Our Ref: WA/50/25/DOC

Approval of details reserved by condition imposed under reference WA/75/20/PL relating to condition number 3 - surface water drainage scheme, condition number 4 - surface water drainage system and condition number 7 - surface water drainage scheme.

Fleurie Nursery Lake Lane Barnham PO22 0AL

Arun District Council have decided to **REFUSE details reserved by condition for the following reasons:**

Drainage
SE Glass exceedance
Bund area and level

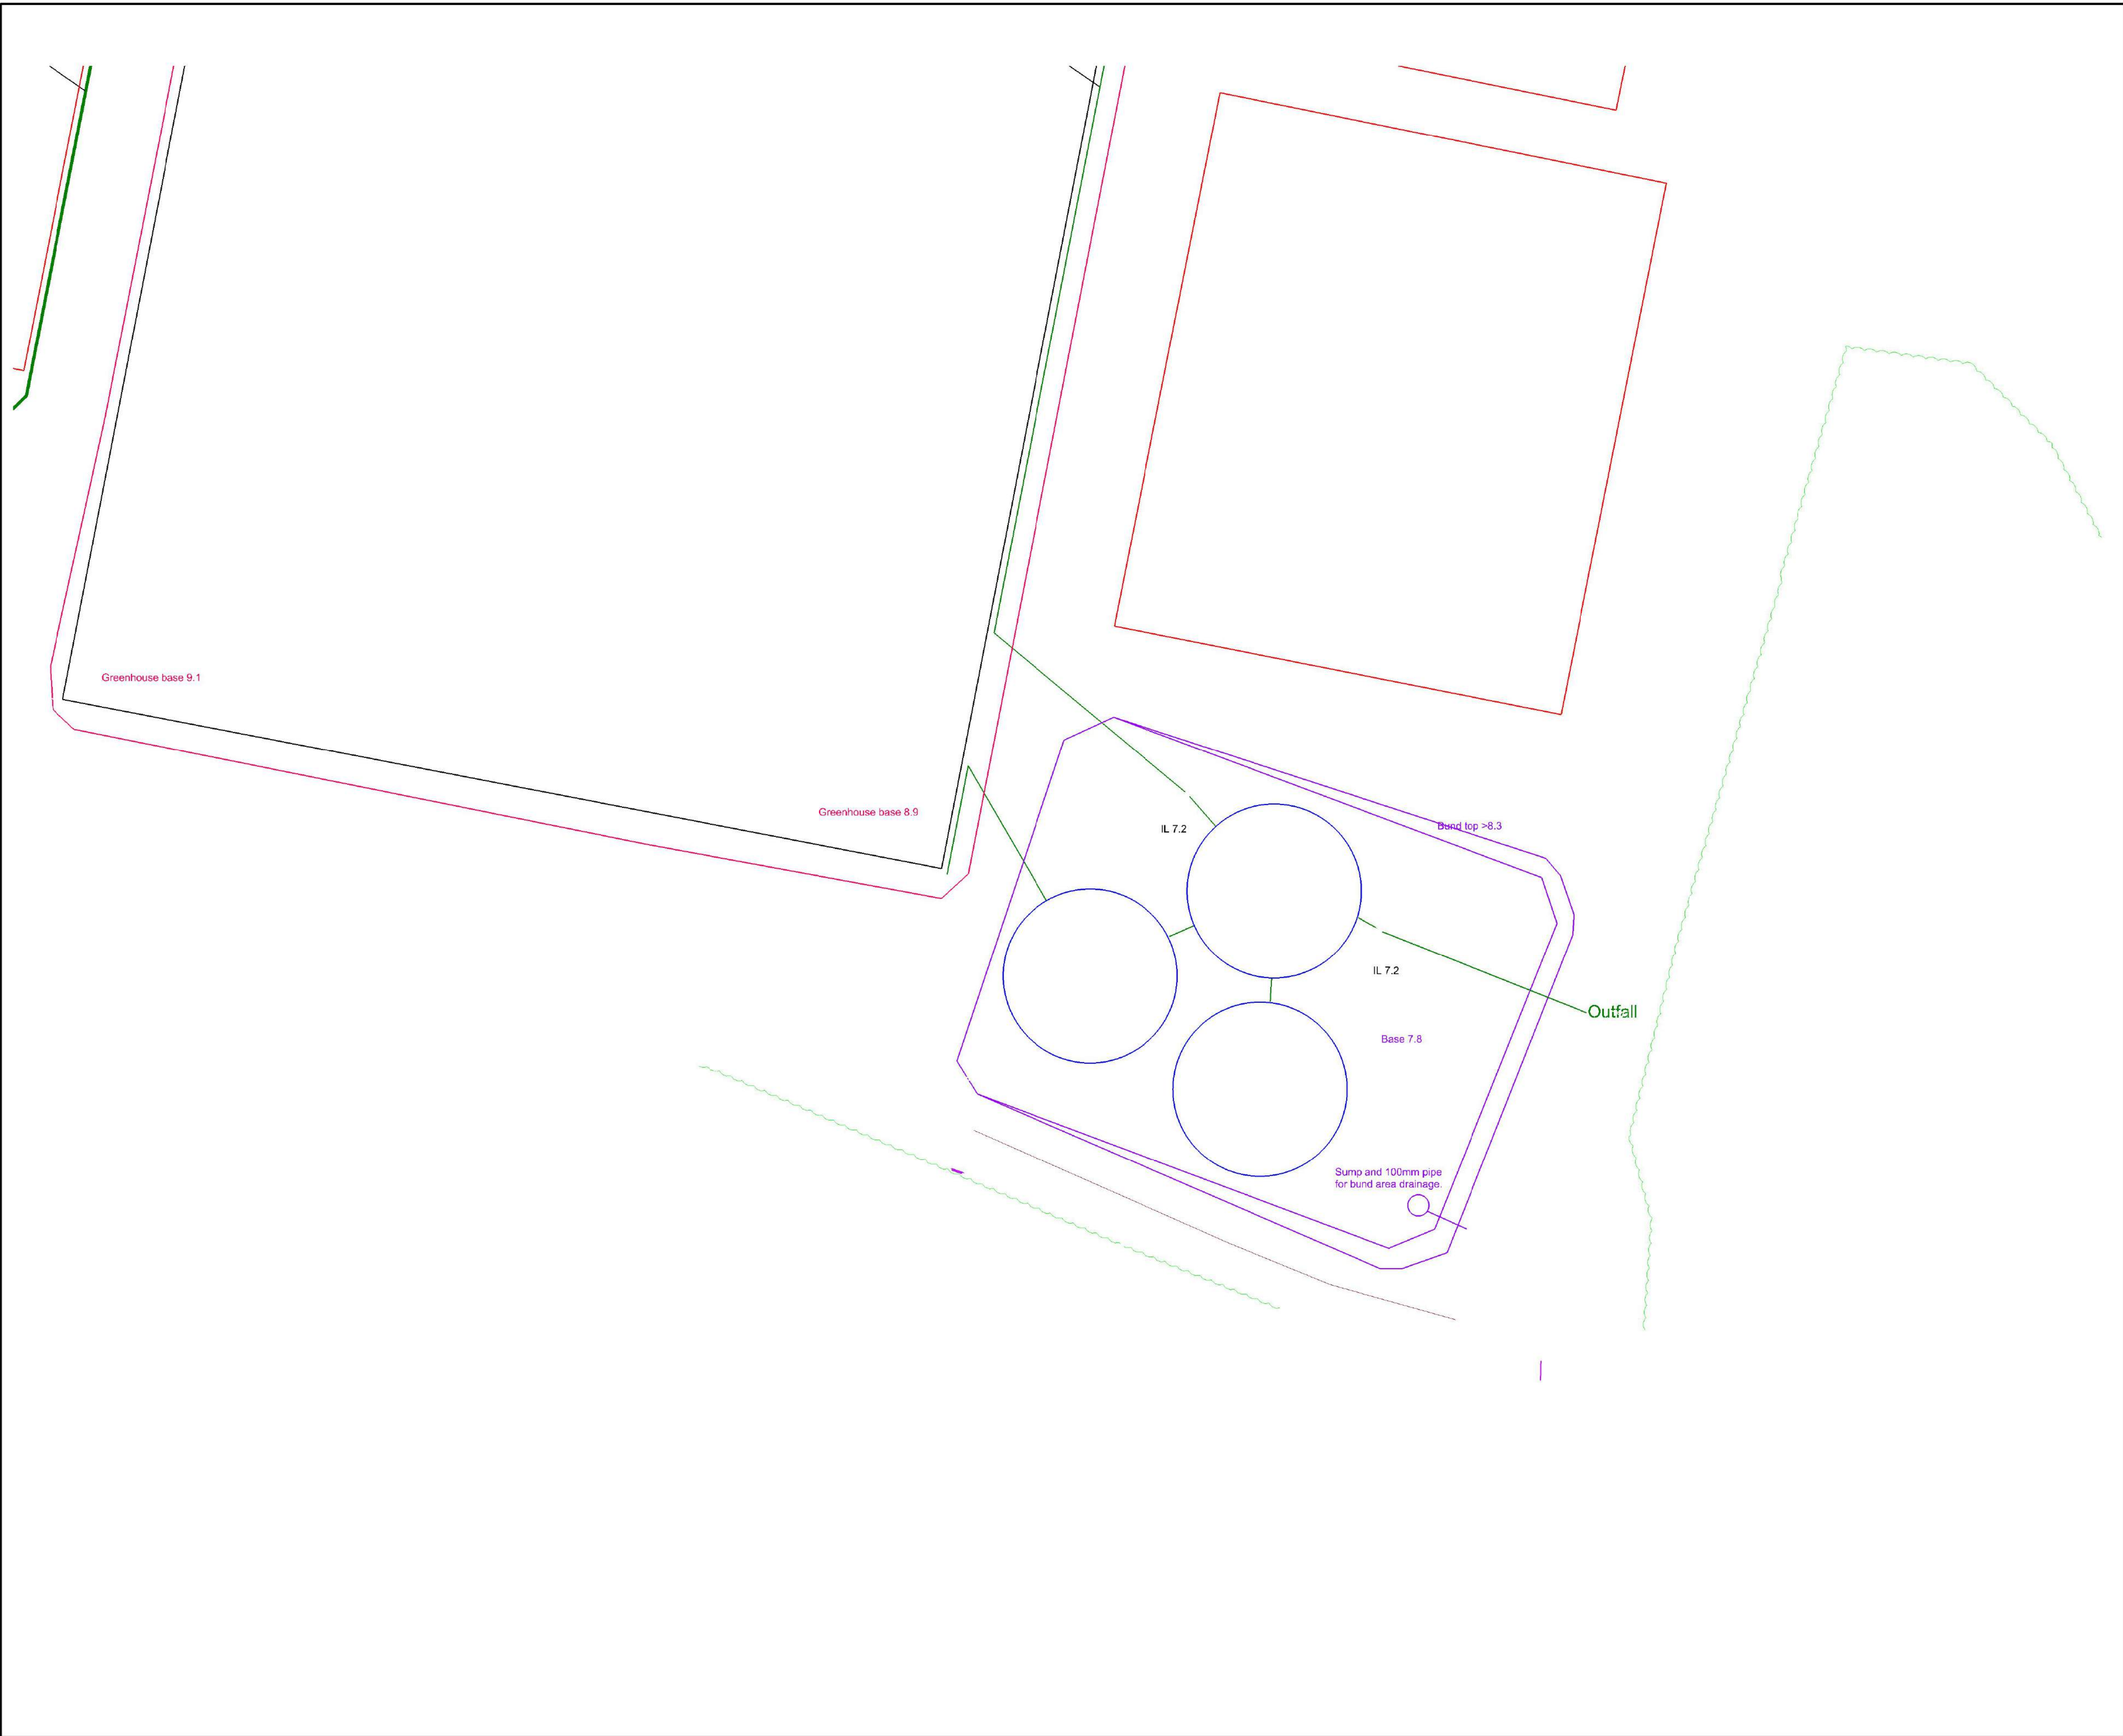
Detailed designs with supporting design construction details with clear cross references to proposals need to be provided. The final direction of exceedance flows is unclear. It appears in some instances that both the bunds and tanks may impede on maintenance easements associated with the existing watercourse.
